**WELWYN HATFIELD BOROUGH COUNCIL
EXECUTIVE DIRECTOR - PLANNING, PUBLIC PROTECTION AND GOVERNANCE**

Application No: 6/2017/2664/LAWP
Location: Manor Cottage Vineyards Road Northaw Potters Bar EN6 4PQ
Proposal: Certificate of Lawfulness for the erection of 2x single storey side extensions, erection of outbuilding and the installation of dormer widow
Officer: Mr David Elmore

Recommendation: Refused

Existing Elevations

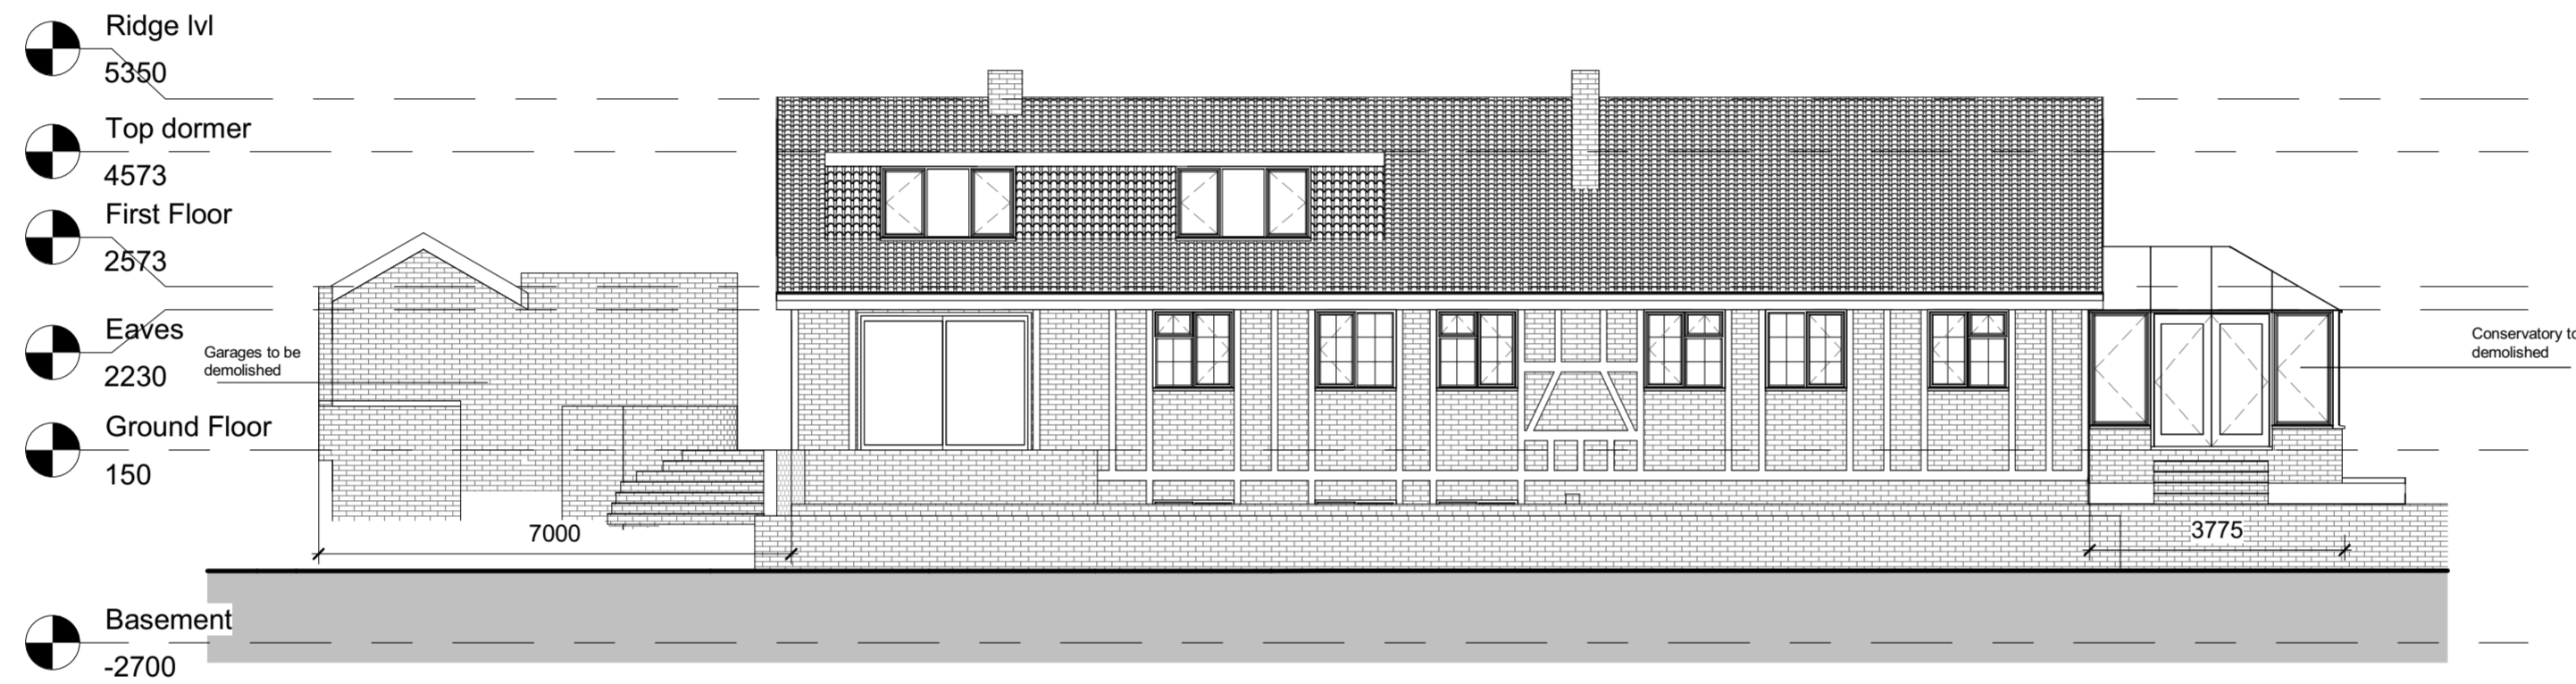
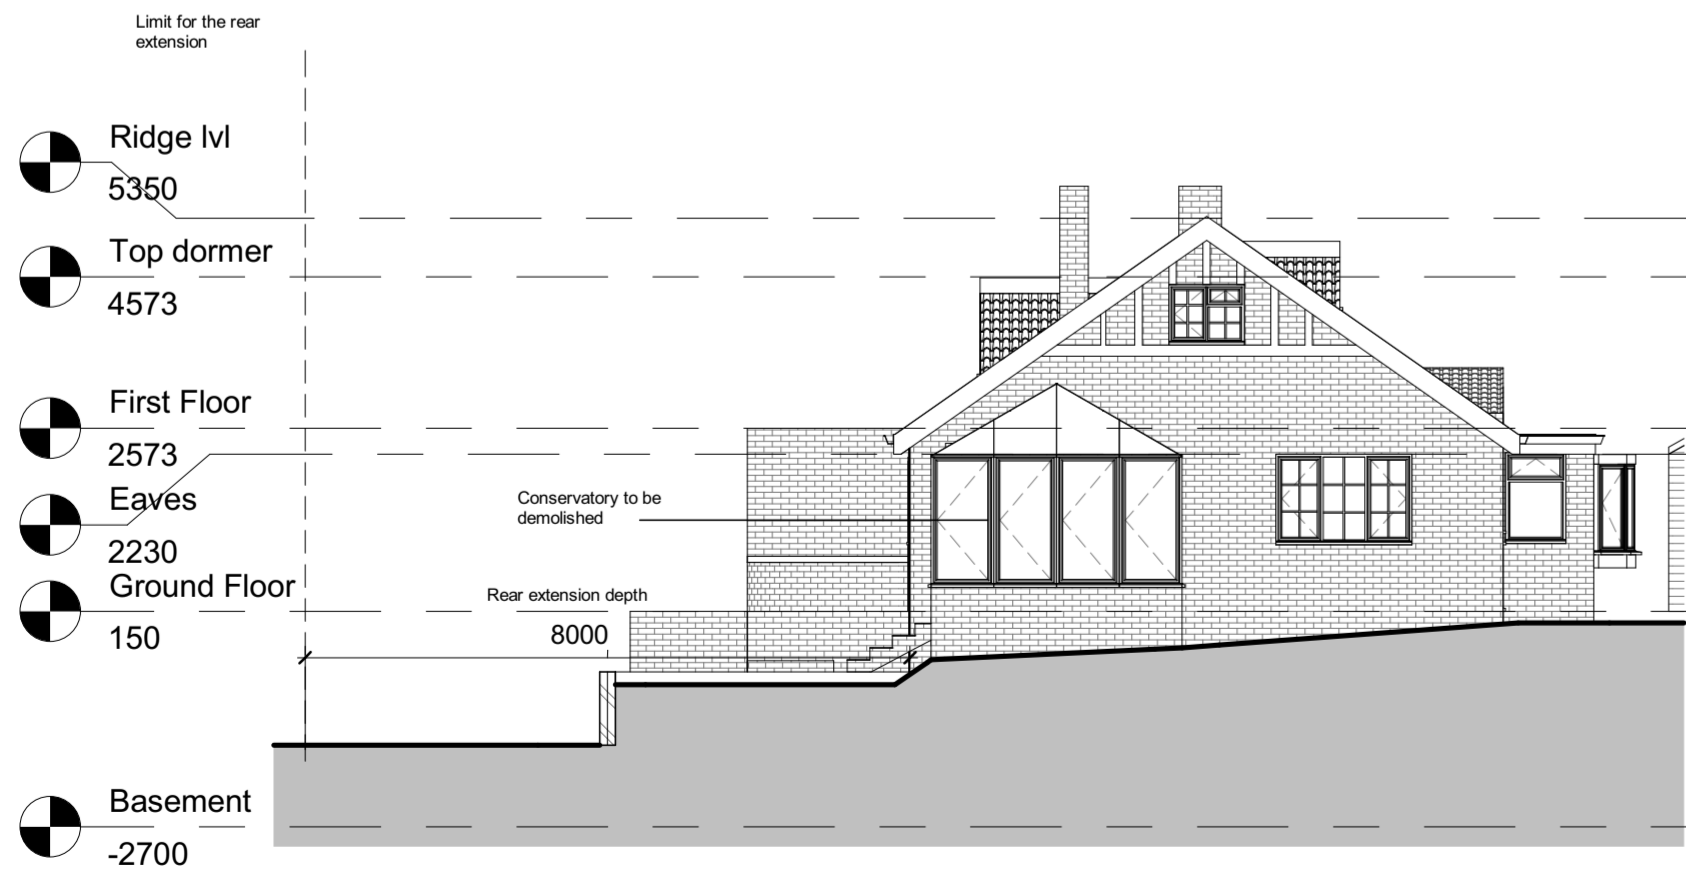
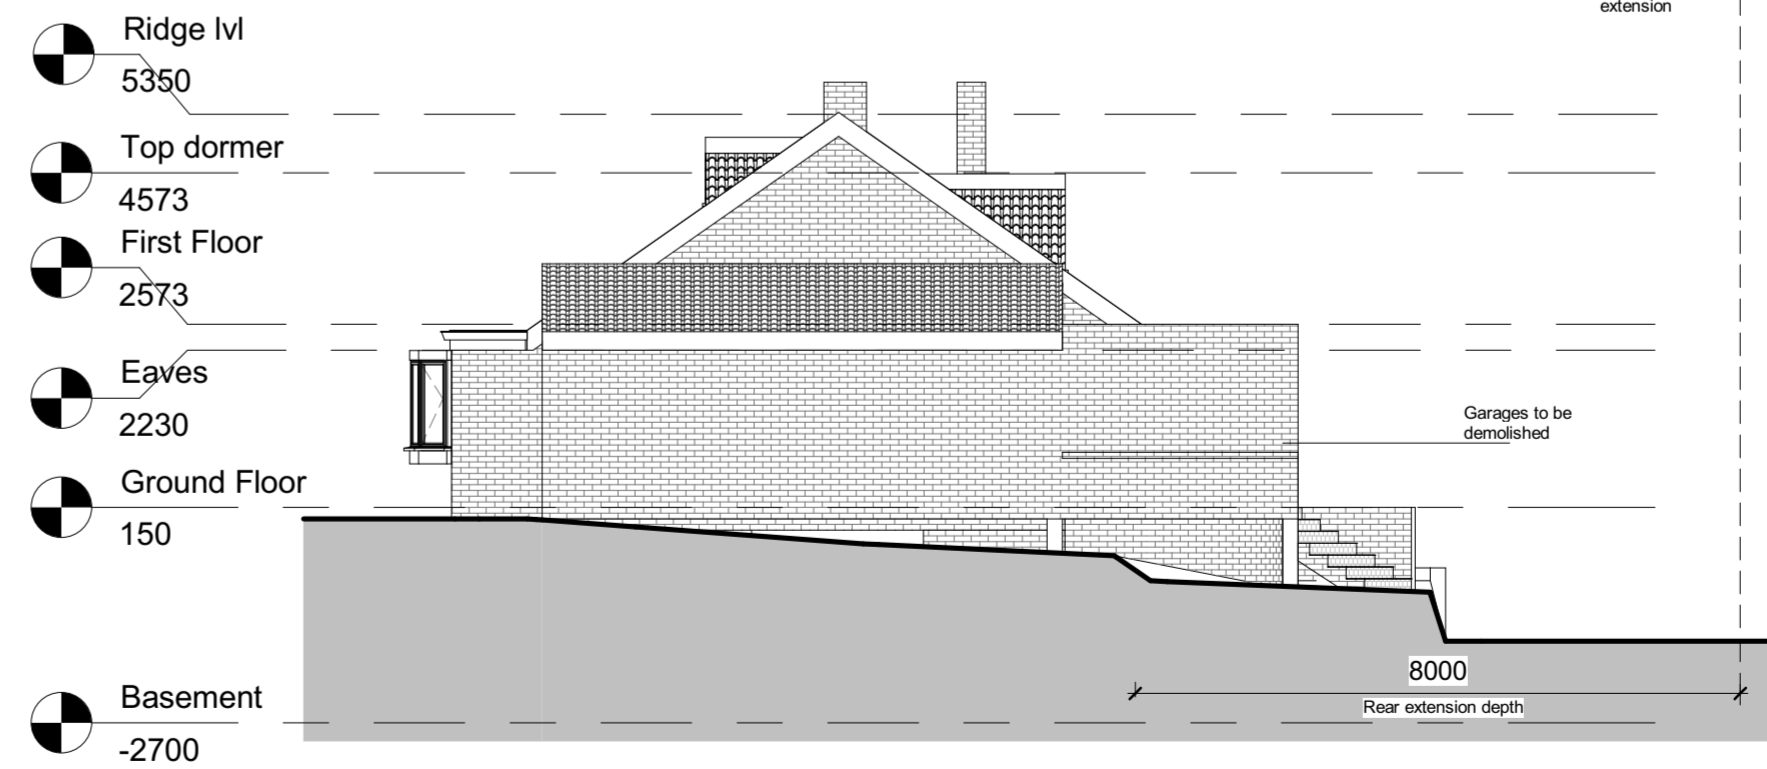
(d) would the height of the eaves of the part of the dwellinghouse enlarged, improved or altered exceed the height of the eaves of the existing dwellinghouse	Y	N
<i>DISCUSSION:</i> <i>The eaves of the side extensions would be 14.4cm higher than the height of the eaves of the existing dwelling dwellinghouse</i>

**DRAWING TITLE**  
Proposed 3D Views

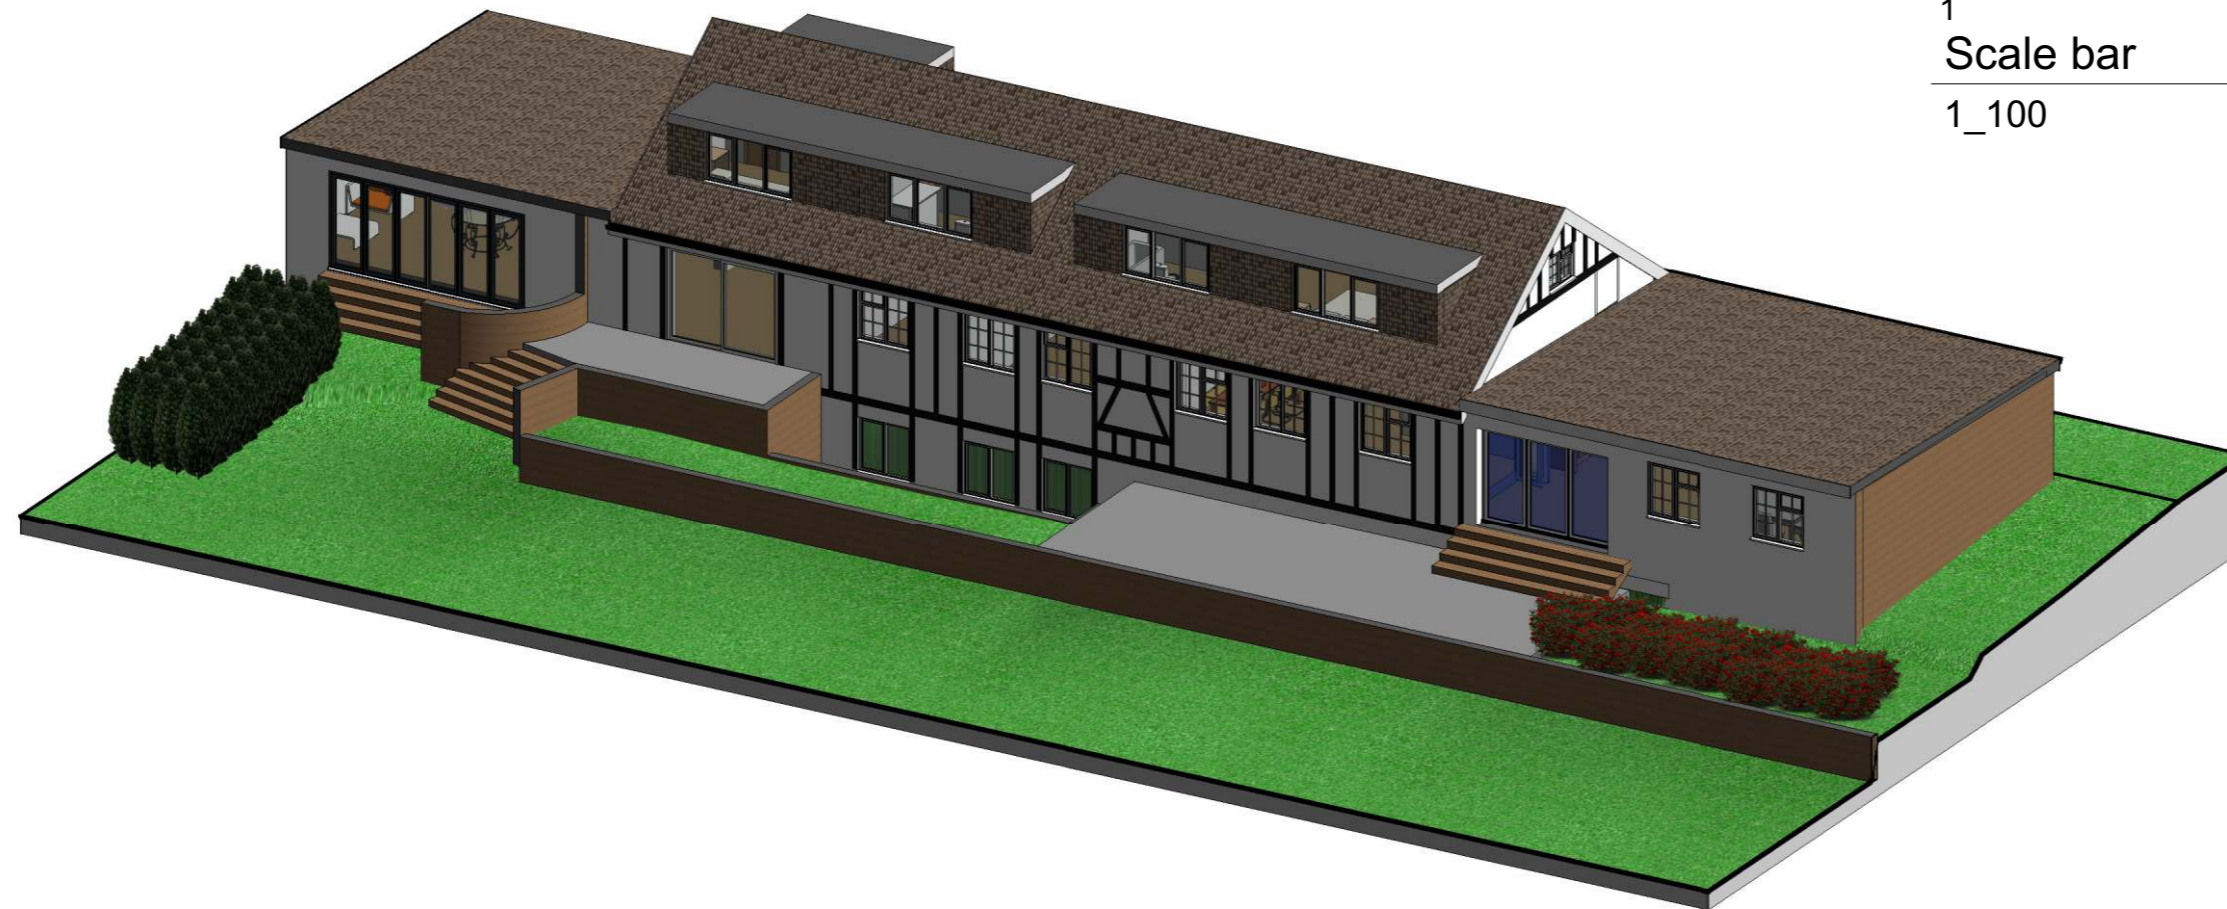
(e) would the enlarged part of the dwellinghouse extend beyond a wall which:- (i) forms the principal elevation of the original dwellinghouse; or (ii) fronts a highway and forms a side elevation of the original dwellinghouse	Y	N
<i>DISCUSSION:</i> <i>The dwellinghouse benefits from a front extension, granted planning permission under ref: E6/1957/1479/. Both side extensions proposed would extend beyond the principal elevation of the original dwellinghouse. The proposal therefore fails to accord with this limitation.</i>

(d) the cubic content of the resulting roof space would exceed the cubic content of the original roof space by more than— (i) 40 cubic metres in the case of a terrace house, or (ii) 50 cubic metres in any other case;	Y	N
<i>DISCUSSION:</i> <i>The original dwellinghouse had a shallow pitched roof with a volume of approx. 60.4 cubic metres. The original roof has enlarged and extended through planning permissions: E6/1957/1479/ & E6/1969/0499/. These extensions together with the dormer windows proposed would increase the volume of the roof to 239.7 cubic metres. As such, the cubic content of the original roof space would in increased by 179.3 cubic metre. The proposal therefore fails to accord with this limitation.</i>

1. The height of the eaves of the proposed side extensions would exceed the height of the eaves of the existing dwellinghouse, and therefore, would fail to comply with Schedule 2, Part 1, Class A, A.1(d) of the Town and Country Planning (General Permitted Development)(England) Order 2015 as amended.

2. The proposed side extensions would join onto to an existing enlargement of the original dwellinghouse, and therefore, would exceed the limits set out in Schedule 2, Part 1, Class A, A.1(e, j and ja) of the Town and Country Planning (General Permitted Development)(England) Order 2015 as amended.

3. The cubic content of the resulting roof space would exceed the cubic content of the original roof space by more than 50 cubic metres, and therefore, fails to comply with Schedule 2, Part 1, Class B, B.1(d) of the Town and Country Planning (General Permitted Development)(England) Order 2015 as amended.
